September 21, 2023

Project: Madrona Crest Lot 9, 3605 86th Ave SE, Permit # 2306-185

I have reviewed the SDCI review correction notice and have the following responses to the Structural items. Please note that the numbers of my responses correspond to the numbers on the correction sheet.

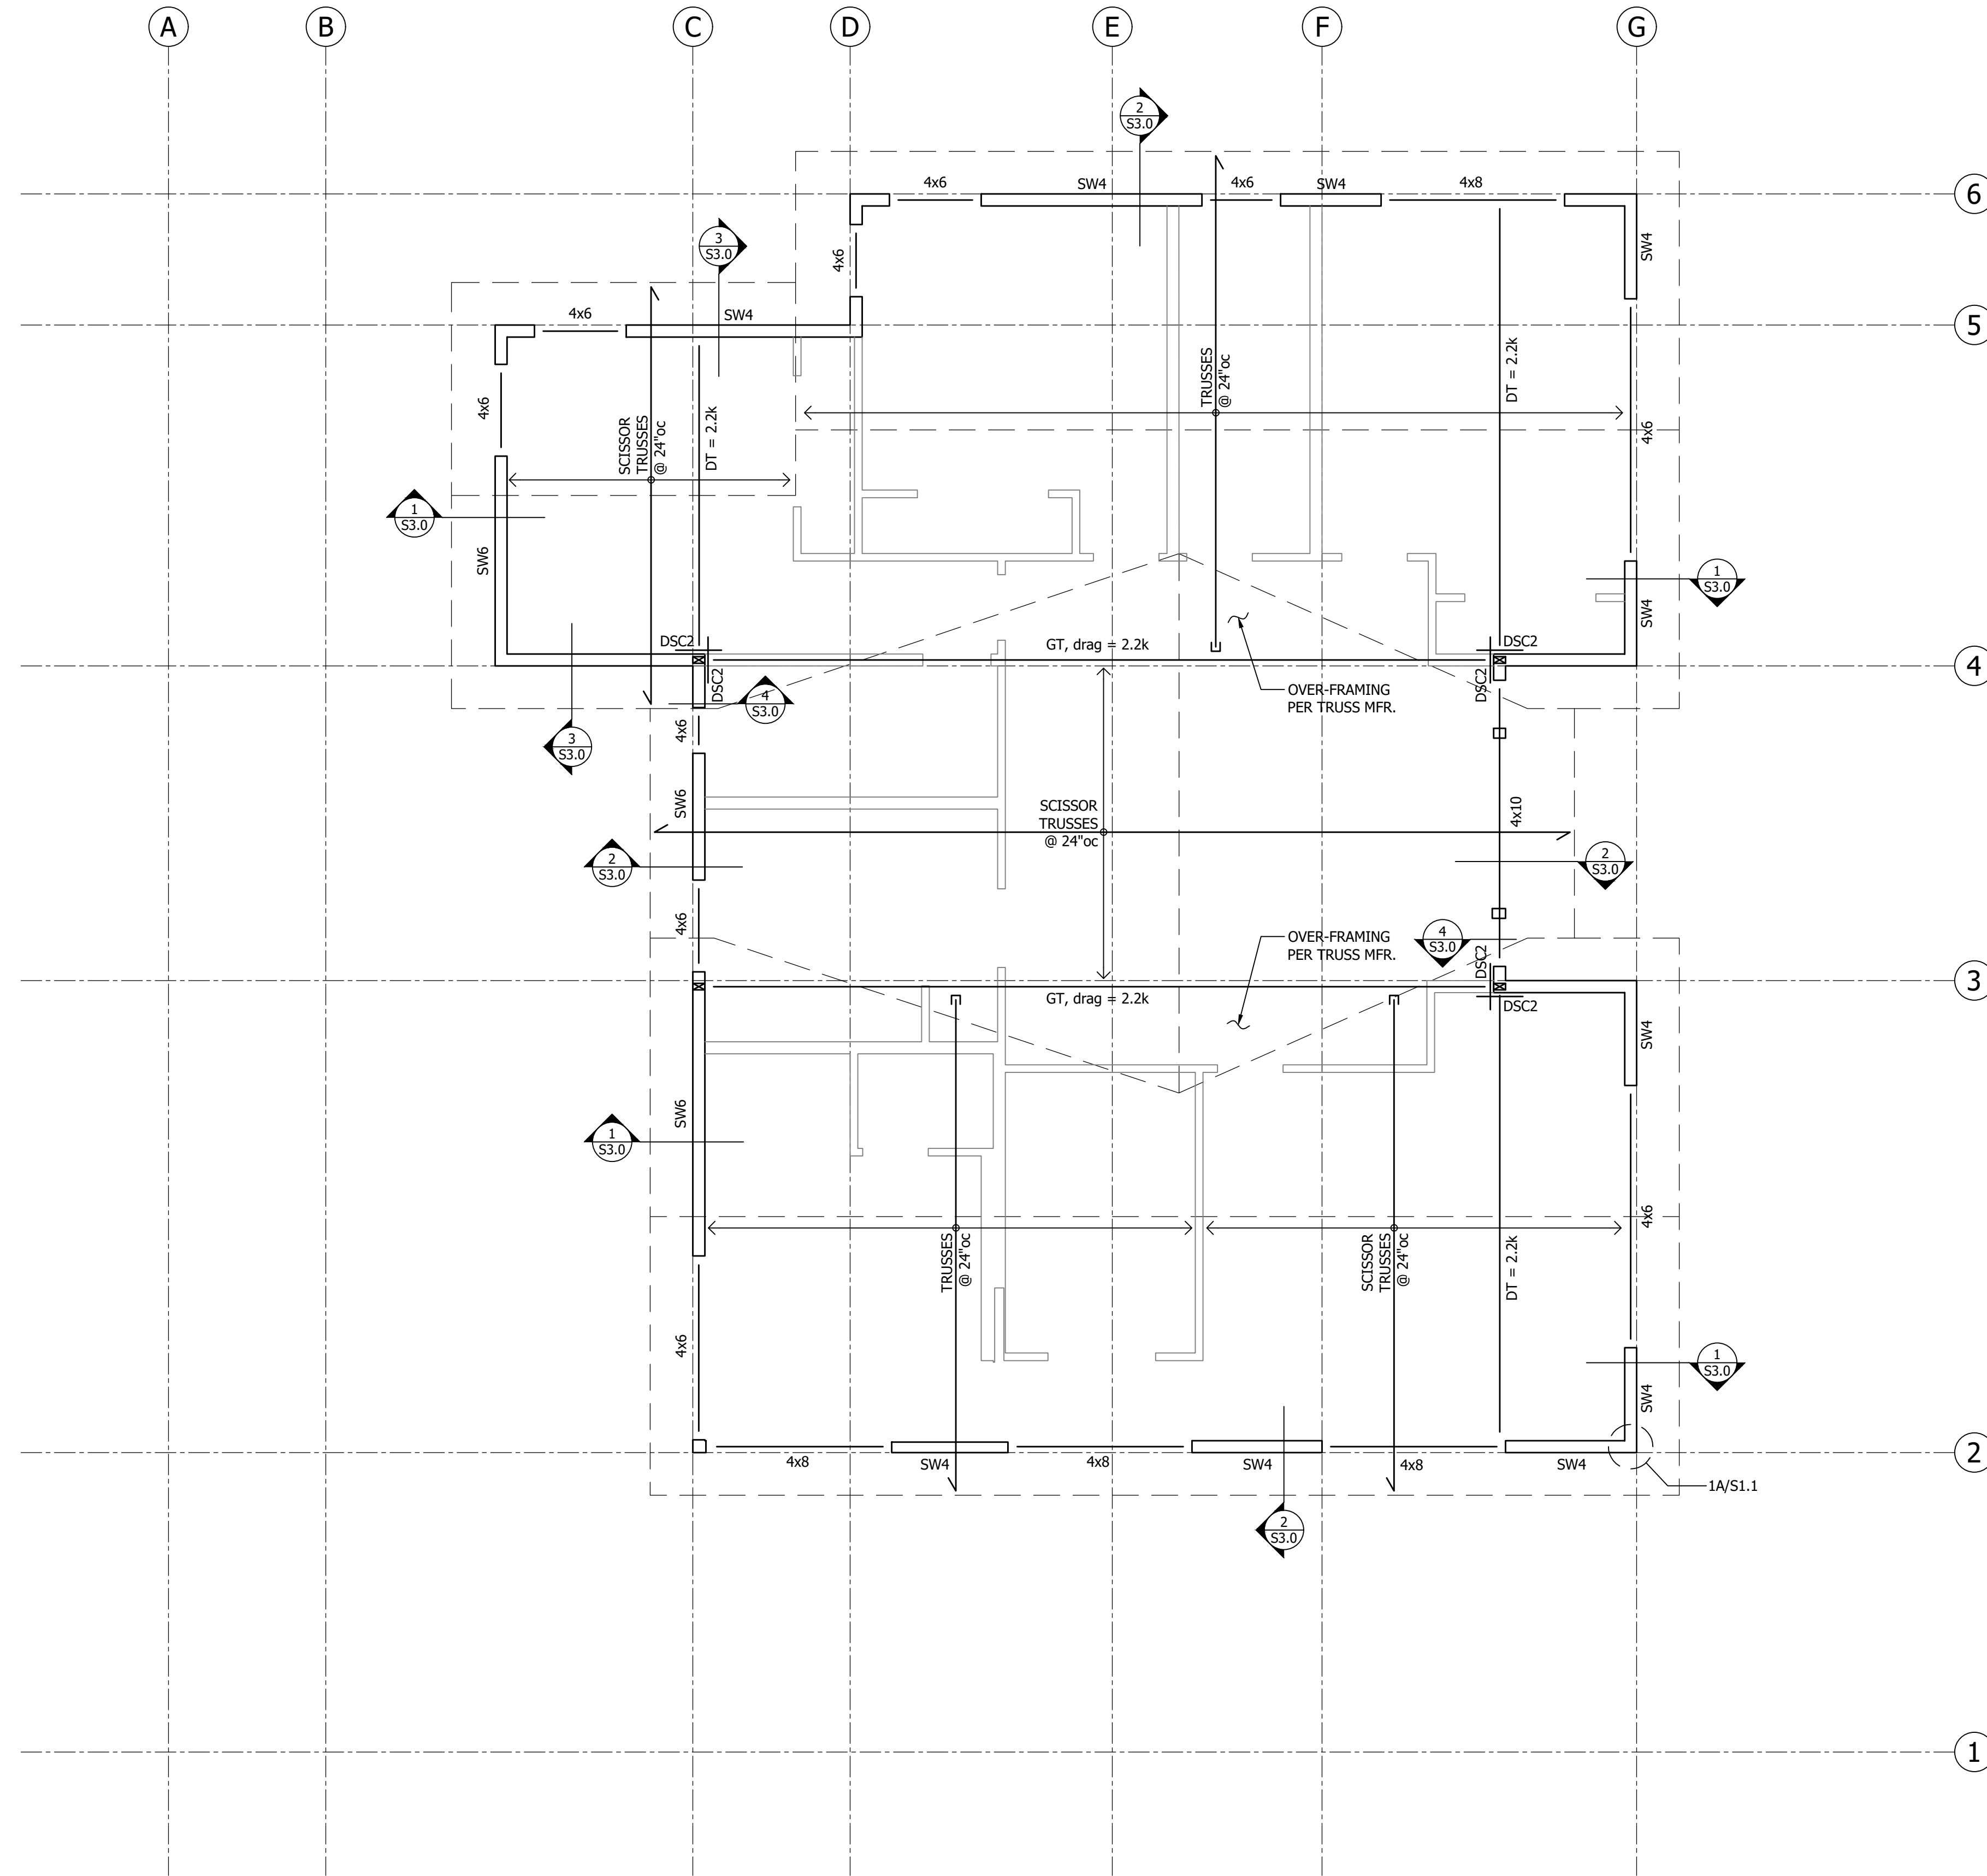
4. The Prefabricated Connector Plate Wood Trusses notes on Sheet S2.2 identify the design criteria for the truss manufacturer. There is a top chord snow load of 35 psf identified on this sheet; is this really intended? The snow load is noted as 25 psf on Sheet S1.0 of the Structural Notes. Please resolve discrepancy.

5. Detail 2/S3.0 is cut at two locations between Grids 3 & 4 on the Roof Framing Plan, Sheet S2.2, at the scissor trusses. Is Detail 3/S3.0 actually intended?

Response: The design snow load is 25 psf, there are no requirements for drifting or unbalanced snow loads, this information has been corrected on Sheet S2.2.

Response: While there are vaults in the Scissor Truss profiles the bottom chord is level at these locations so detail 2/S3.0 is deemed more appropriate. Reference section 2/A4.0.

11 Isolated Post Footing  
3/4" = 1'-0"

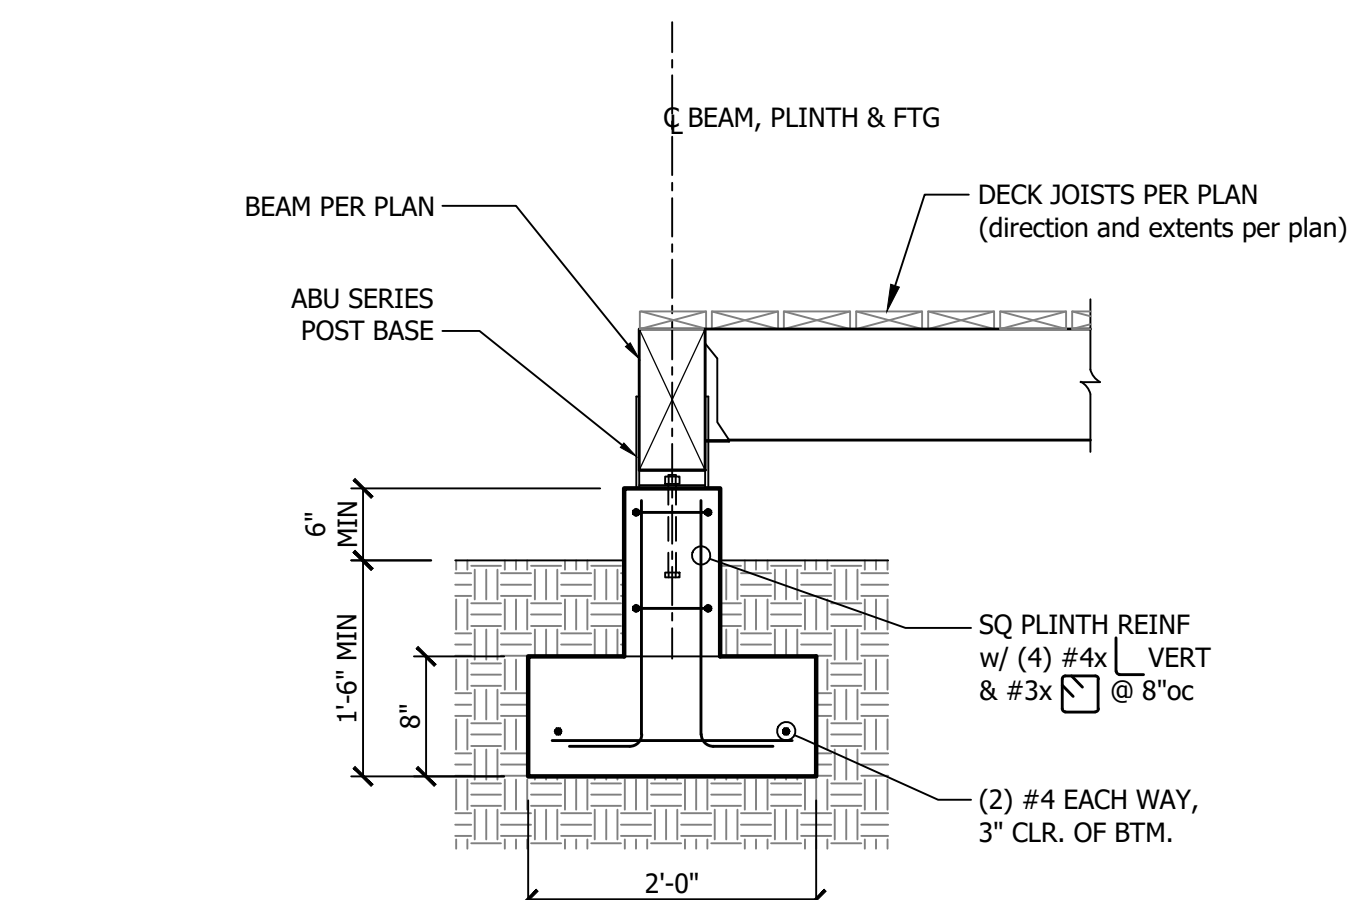
7. Provide adequate reinforcing in the concrete plinth to confine reinforcing and anchor bolts at the top of the column in Details 11 & 12/S3.1 per ACI 318 10.7.6.1.6. Transverse reinforcement must be distributed within 5" of the top of the column or pedestal and must consist of at least (2) #4 or (3) #3 bars.

Response: The plinth in details 11 & 12/S3.1 can be defined as pedestals per ACI 318-14 Chapter 14 and can be designed with plain concrete. The pedestal should see no flexural load and the reinforcement is for serviceability issues such as reducing cracking and spalling over time due to exposure. I have added a max. height dimension to 11 & 12/S3.1 for clarity so that these items are defined as a pedestal.

1 Strap to Beam Below  
3/4" = 1'-0"

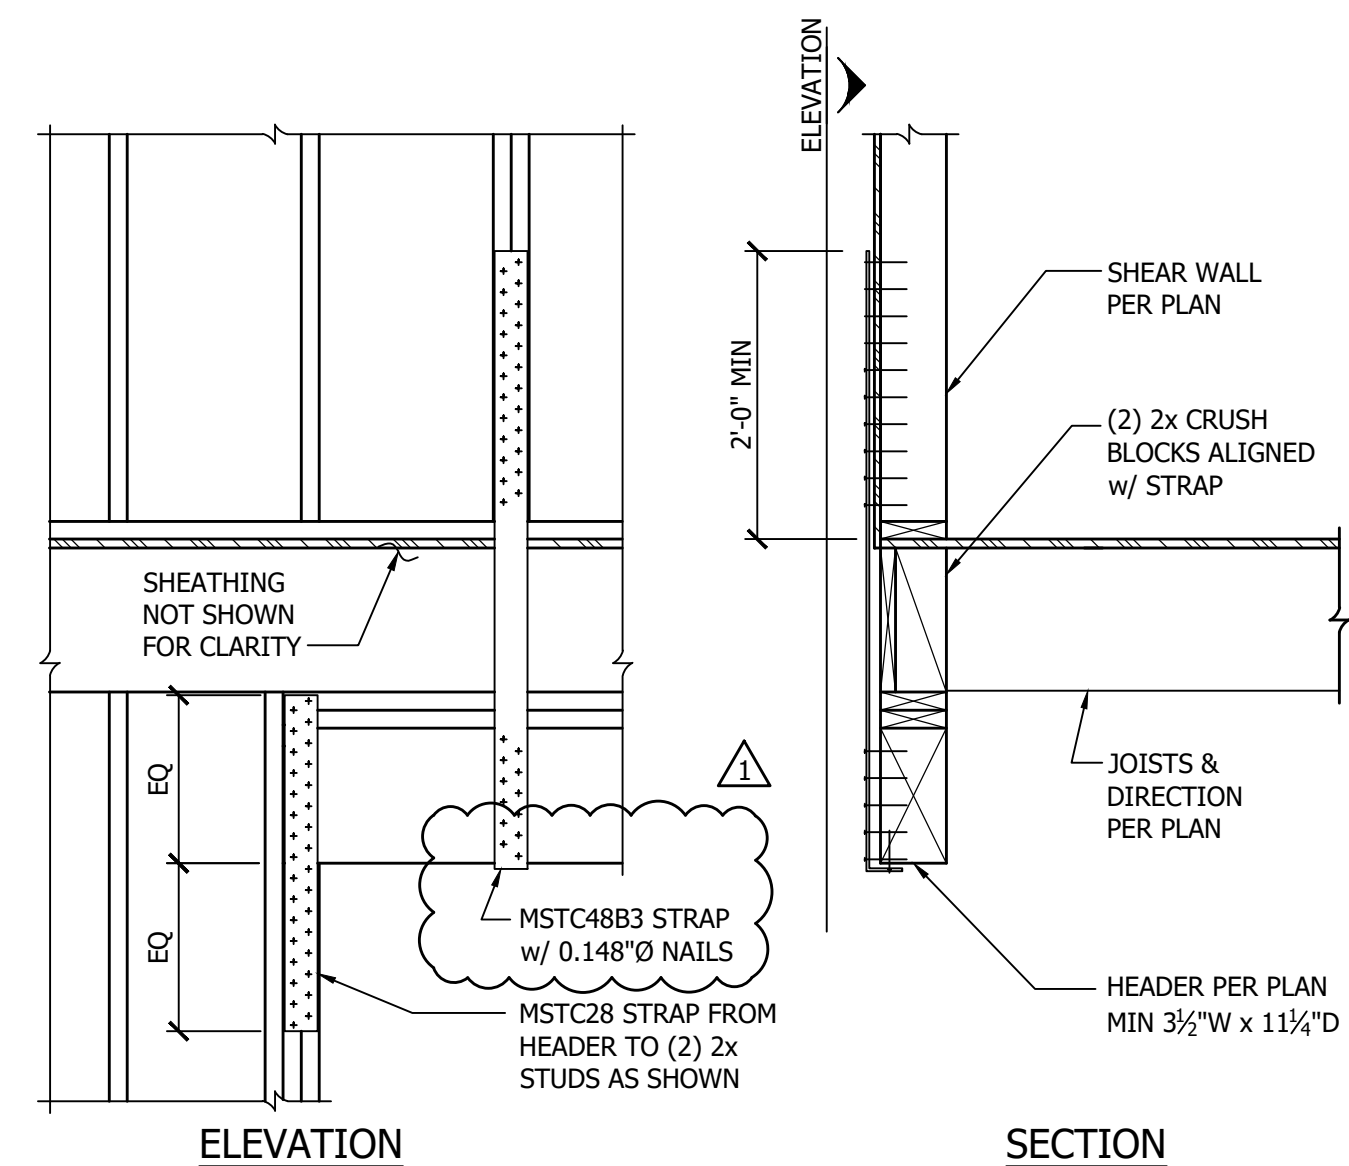
19. Please verify that the CS16 holdown straps have sufficient capacity for the shear walls along Grids B/C on the Upper Floor Framing Plan, Sheet S2.1. Where strapping to an LSL, it appears these straps would not have a sufficient end length to get the full capacity. At this location, Detail 1/S3.2 is cut which shows an MSTC48B3 strap instead of a CS16 strap. Please resolve discrepancy.

Response: The straps along this lateral line have been revised to MSTC40 for walls and deep beams, or to 1/S3.2 at the 11-7/8" LSL beam, see revised Sheet S2.1.
